CITY OF ALBUQUERQUE

July 6, 2021

Re: **Chase Bank**
11004 Montgomery Blvd NE
Traffic Circulation Layout
Engineer's Stamp **Date: None Provided** (G21-
D018A(B))

SHEET NUMBER
C1.03

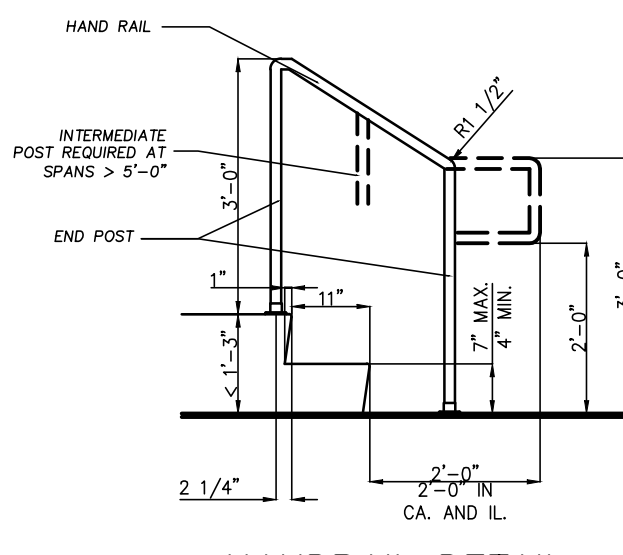
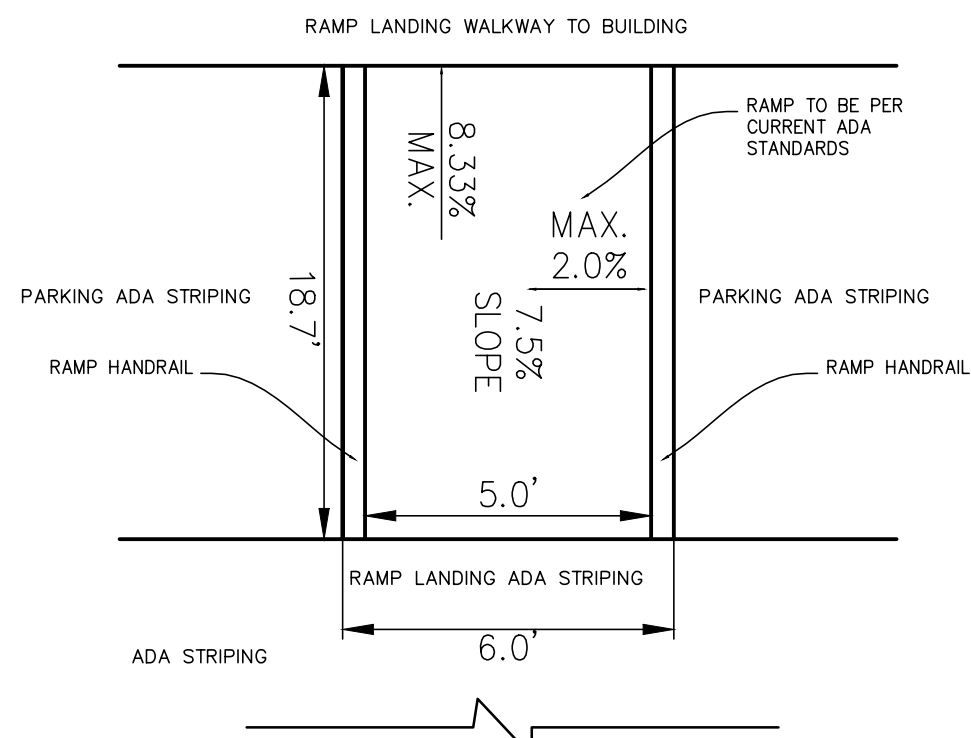
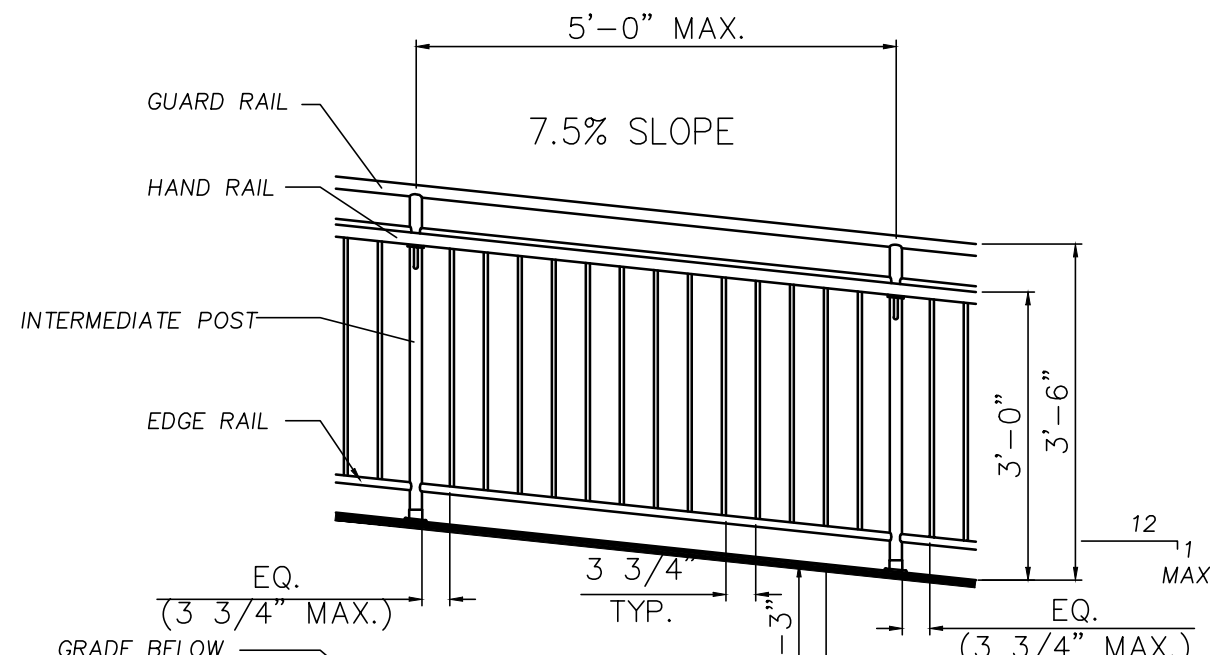
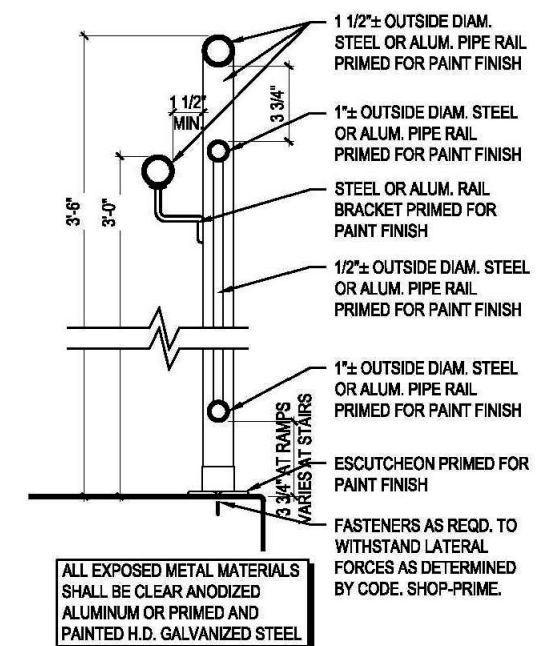
1. The traffic circulation layout must be stamped, signed, and **dated by an engineer** or architect licensed in the state of New Mexico. **The date was not provided on the resubmittal of the site plan.**
2. Provide the receipt for the resubmittal fee.
3. Sheet C1.03:
 - General Notes 7 needs to be remove since there are not drivepads being addressed.
 - Construction Note J remove since no drivepad are being proposed.
4. Sheet C1.02:
 - ADA curb ramp detail. Do you need this detail? If not, please remove.
 - Ramp detail doesn't show the slop and how it fit in the overall scheme fronting building.
 - Bollard detail: Add note to paint bollard yellow.
5. Please provide an over all details/full segment of proposed handrails (**Needs to follow ADA Accessible Guidelines**).

Concern: What is going on with the existing sidewalk fronting building? There is a +8" difference in elevations. So the concern is how will you address this elevation difference from the existing sidewalk around the corner of building and the ADA accessible requirements? Please provide details on the rise/run of the new proposed access route from ADA access aisle to the front of the building and connection around the corner of existing sidewalk. Include how the handrail will function with the new detail that you will provide (include length, height of ramp and railing). You have 3 steps is not ADA accessible?

Response: Handrail detail provided.
